From:
Sent: 24 January 2024 06:52
To: DCAdmin
Subject: Fwd: 2023/93556 - 216 Woodlands Road, Batley, WF17 0QS

Rev - : DD-MM-YYYY : Initial : Issue.
Drawing Number 23-110 - P - 03

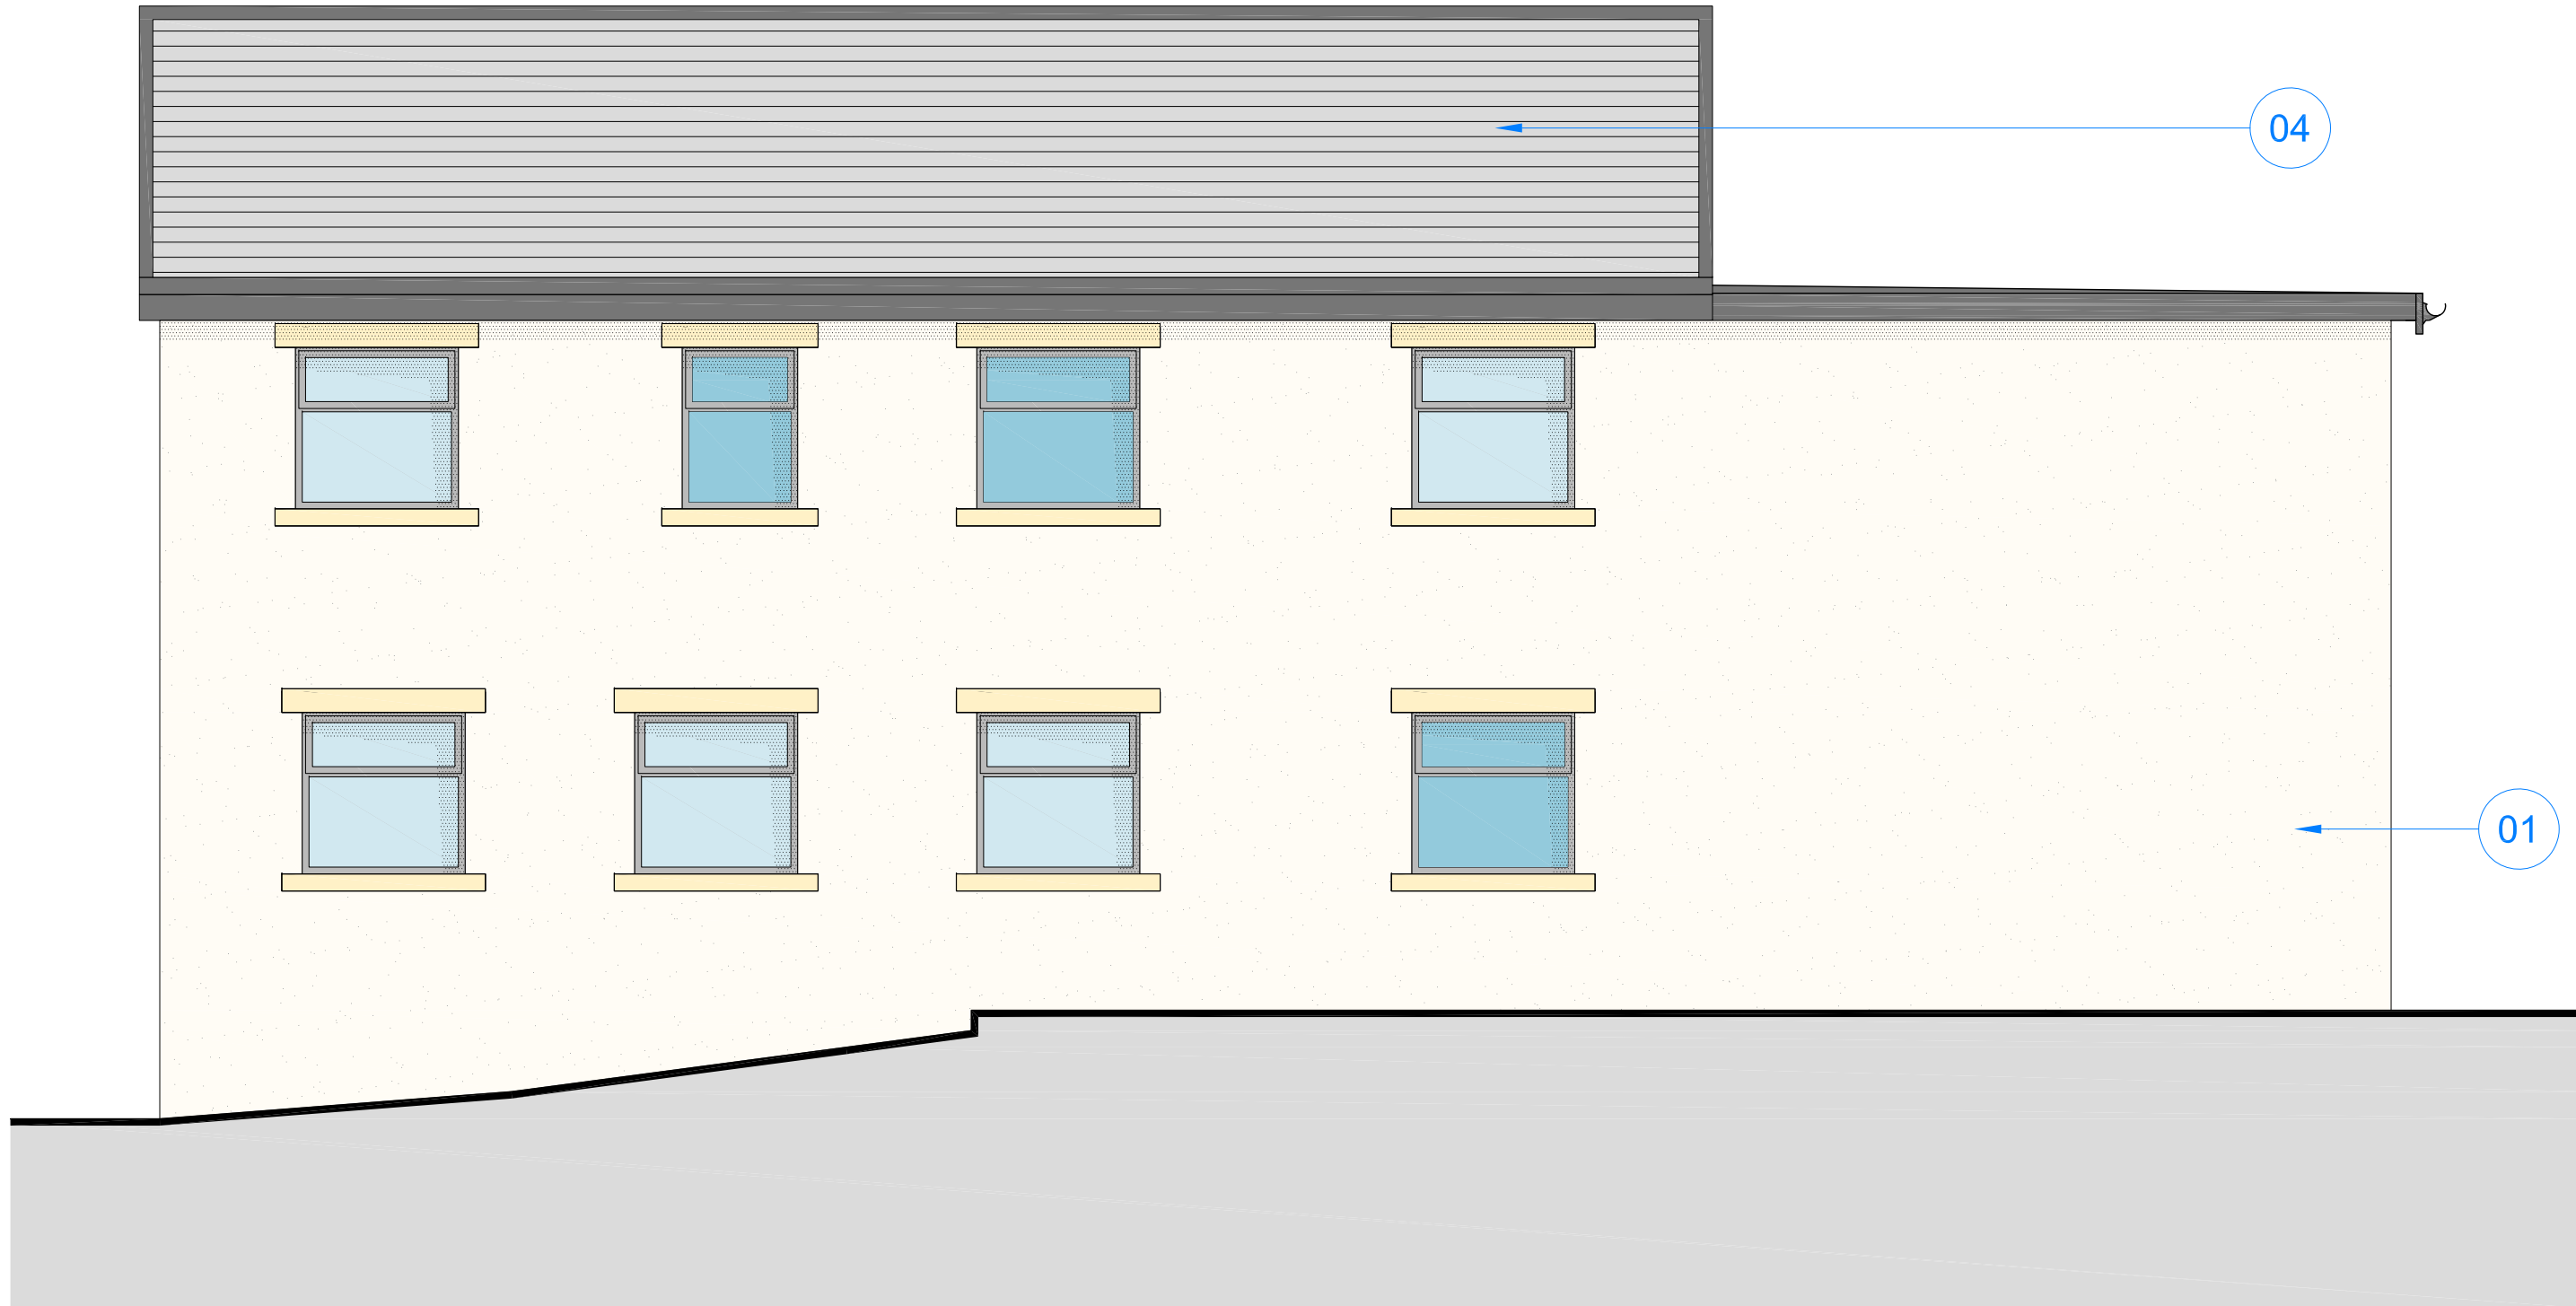
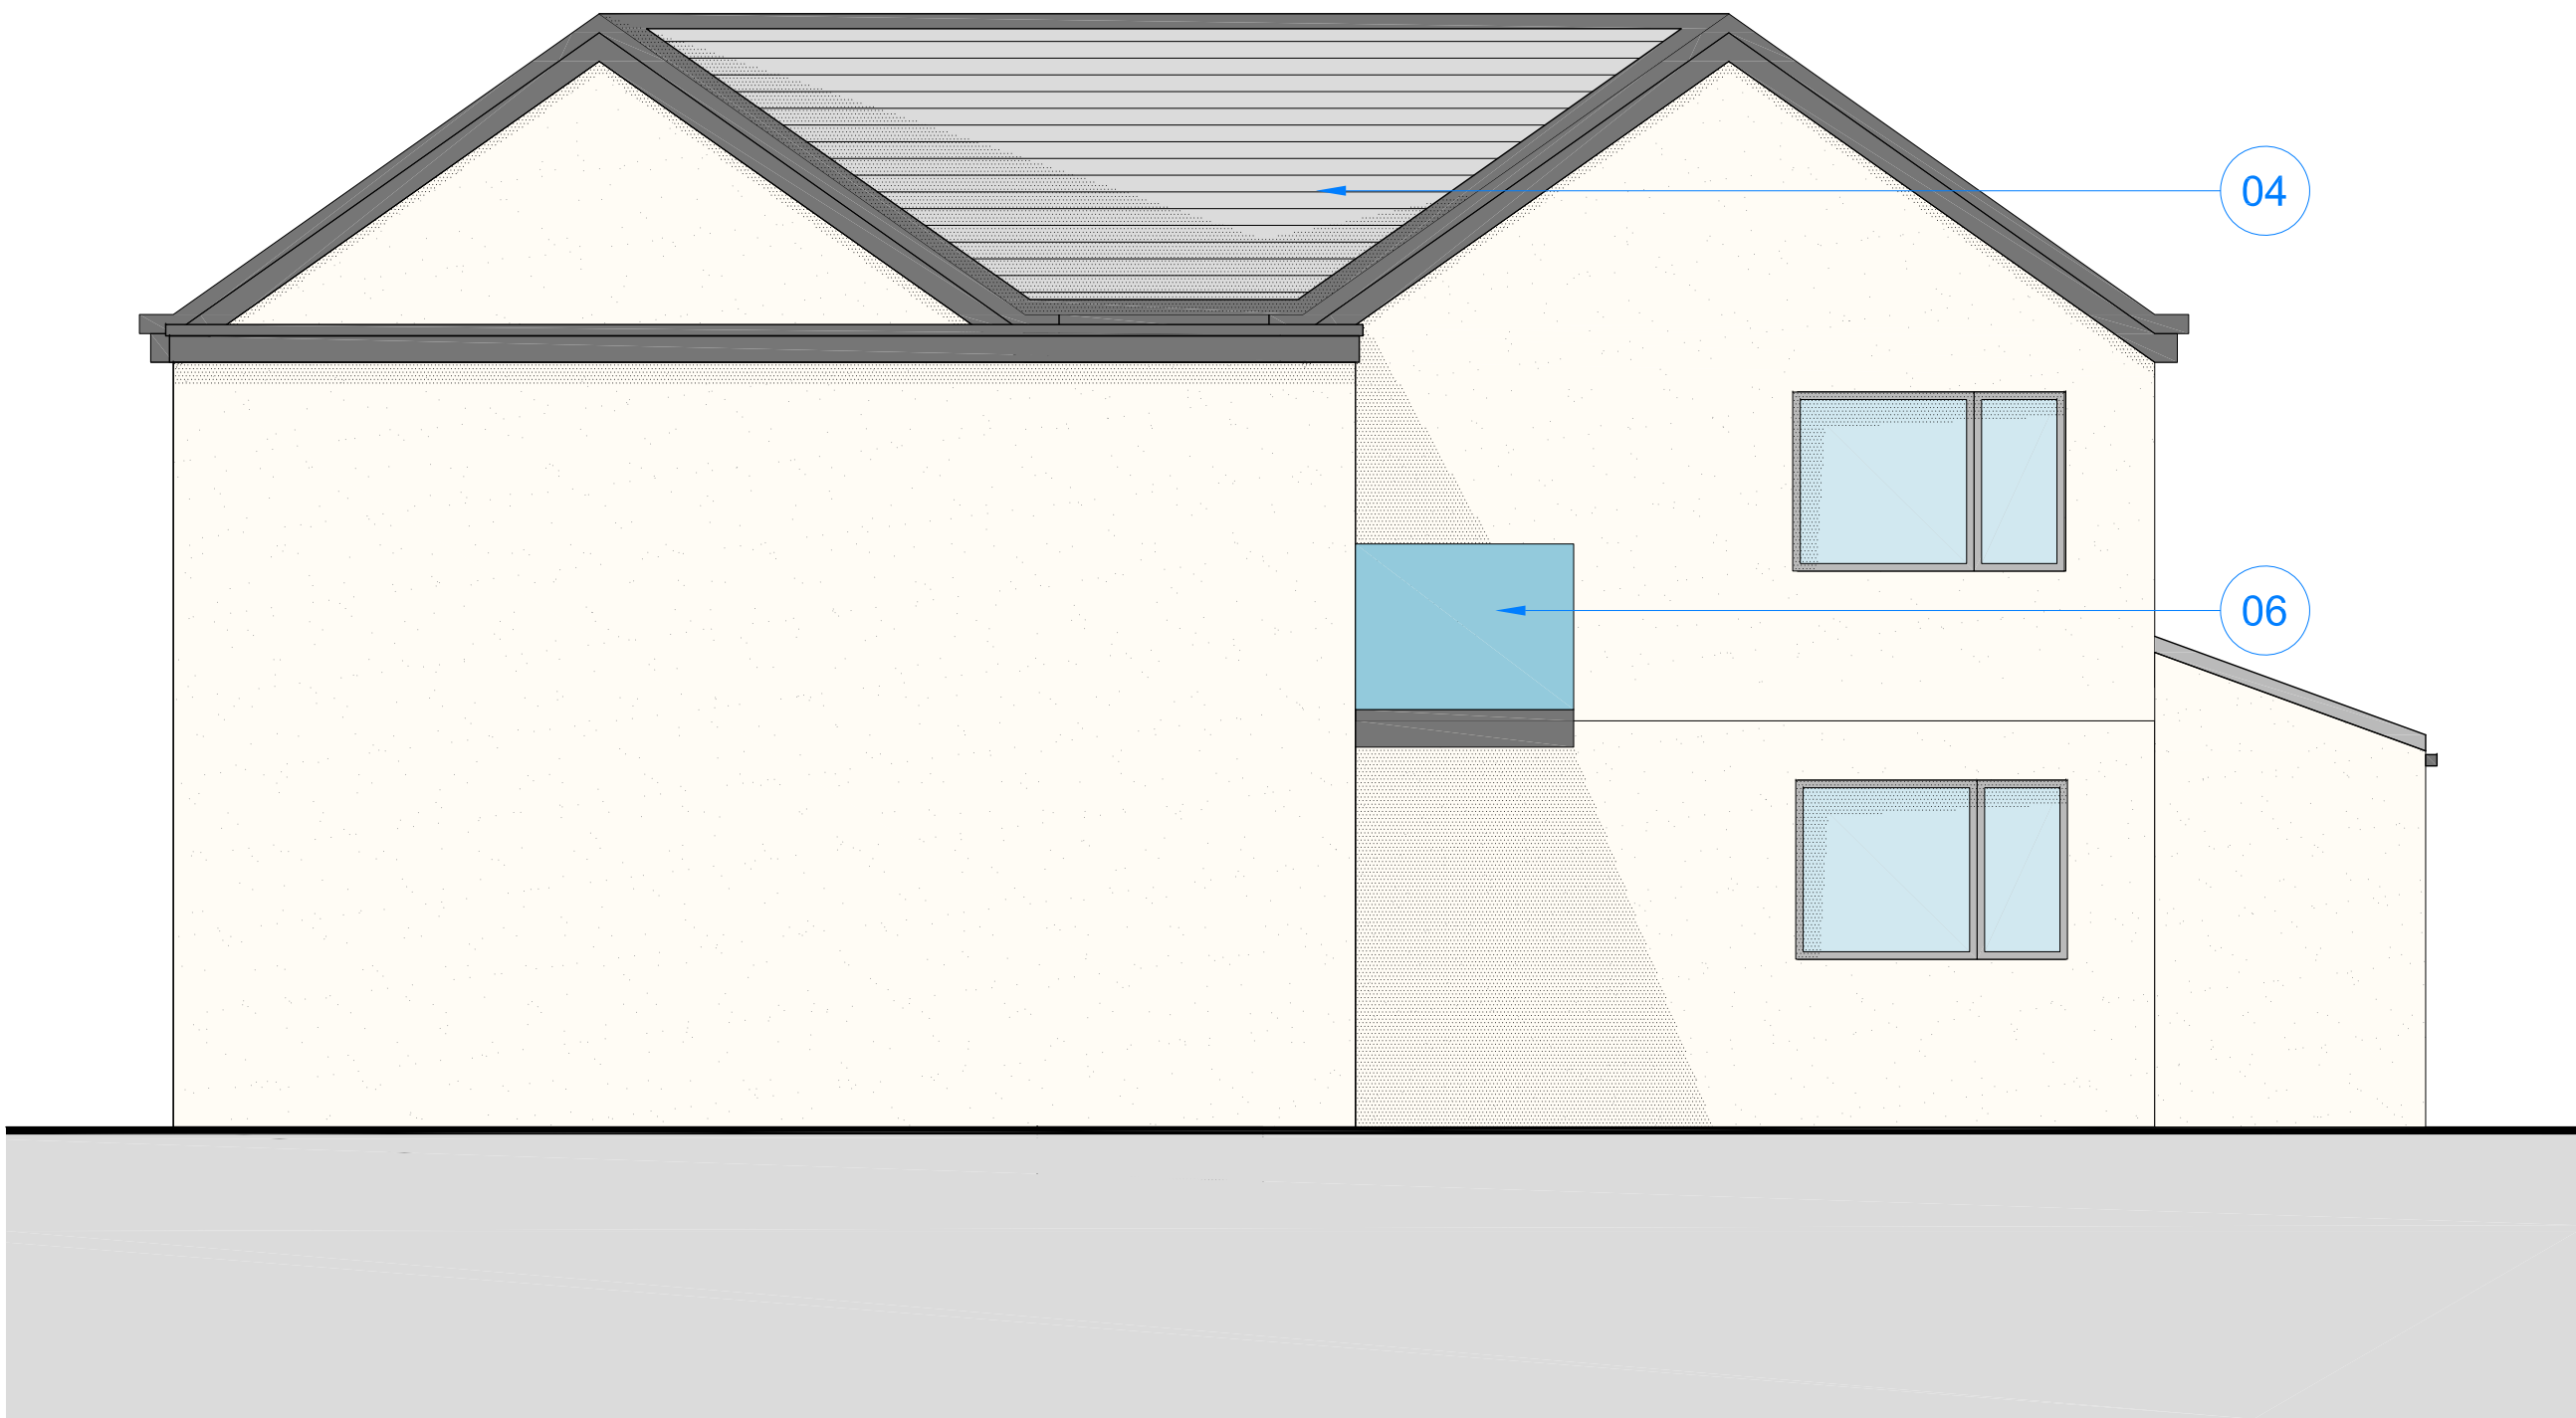
1. The size/ scale/ positioning of this extension- overbearing to neighbouring property, losing the privacy & natural light onto their property. The front elevation is not set back which I was led to believe was good practice when designing extensions, as to reduce the dominant feature of the original dwelling.
2. No parking provision provided on plans- unable to get more than one vehicle on the drive with the current plans
3. No refuse collection area indicated on plans.
4. No structural plans/ calculations or slope provided to assess rear boundary wall.
5. With reference to CCS- location of Air Source Heat Pumps demonstrated on the plans.
6. Tree directly behind garage & shrubs to boundary wall will need to be removed- application form- 'Trees & Hedges' - boxes clearly show nothing to be removed or pruned.

7. Materials finished proposed 'RENDER'. I may be wrong but this is a disgrace to try & propose this as a finished material. There is not another house in the area with a complete render finish.
